**Application No:** 18/00006/DISC

**Proposal:** Discharge of conditions 9 (surface water disposal), 18 (vehicular accesses), 19 (surface water strategy), 23 (open space / play space details), 25 (fire hydrants), 28 (service trenches, pipe runs, etc), 29 (boundary treatments), 30 (Details of the LAP), 39 (site compound), 46 (details and location of bird and bat boxes) of 13/00433/OUT.

**Location:** Land South West Of Bicester Adjoining Oxford Road And Middleton Stoney Road, Bicester.

## Transport

PERMEABLE PAVED CARRIAGEWAY
1:20

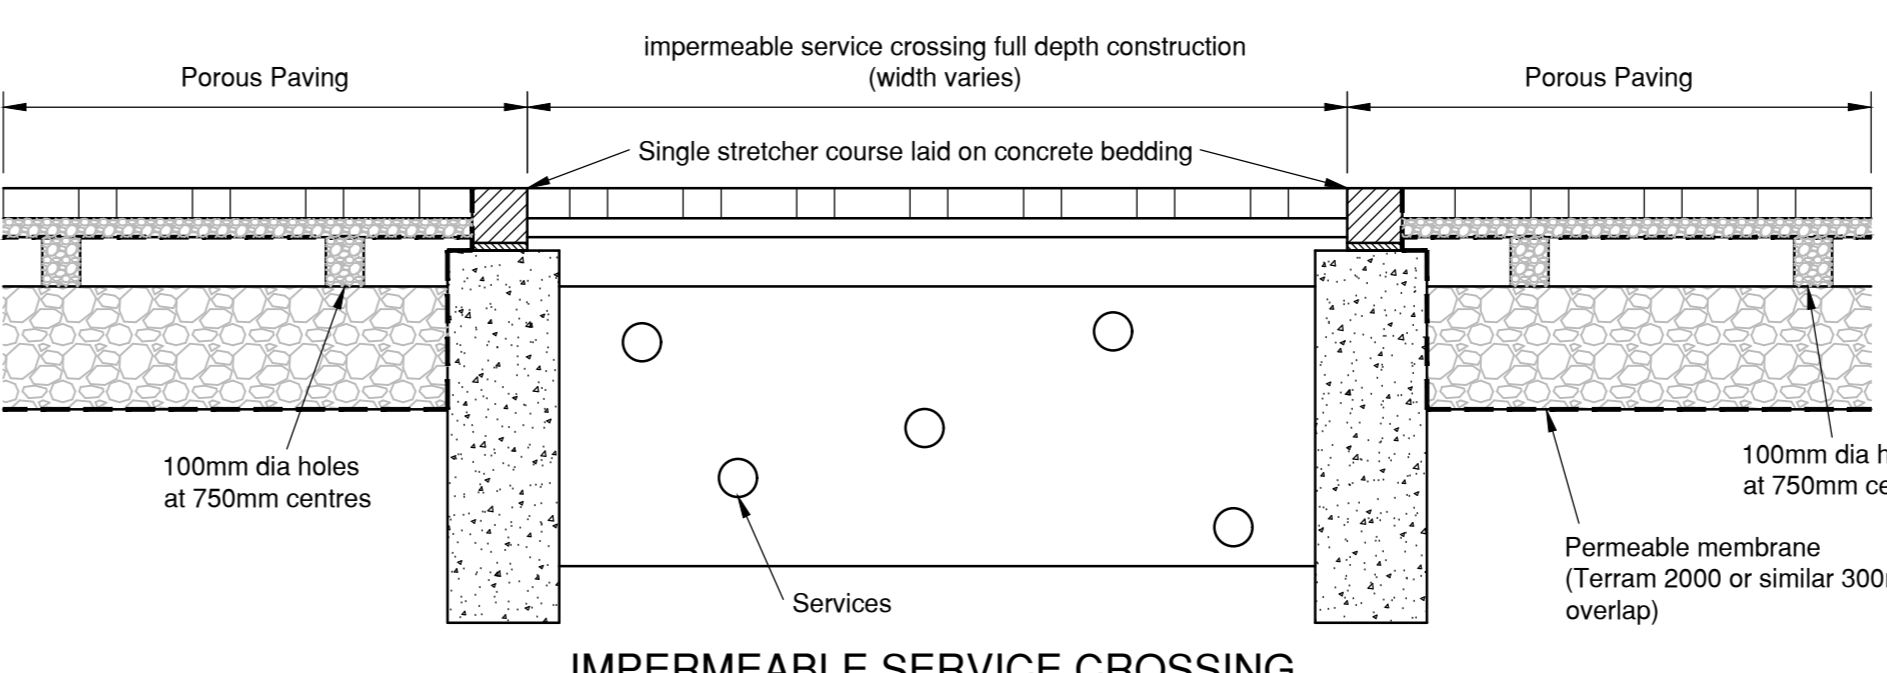
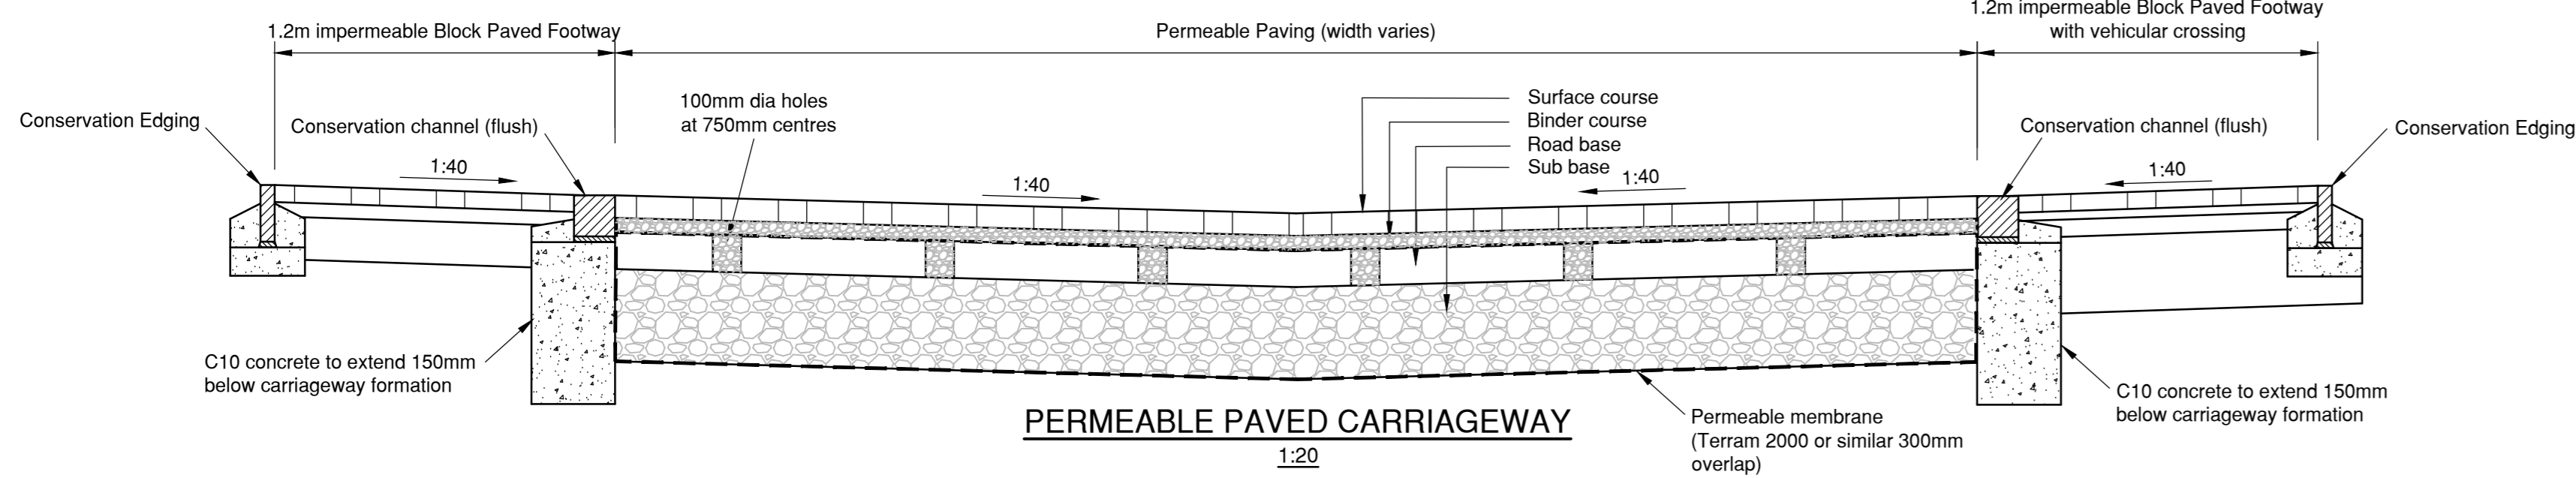
The proposals show Polystorm soakaways for use as part of the surface water management. It should also be clarified whether soakage tests have been undertaken at the site as required by the Kingsmere Code?
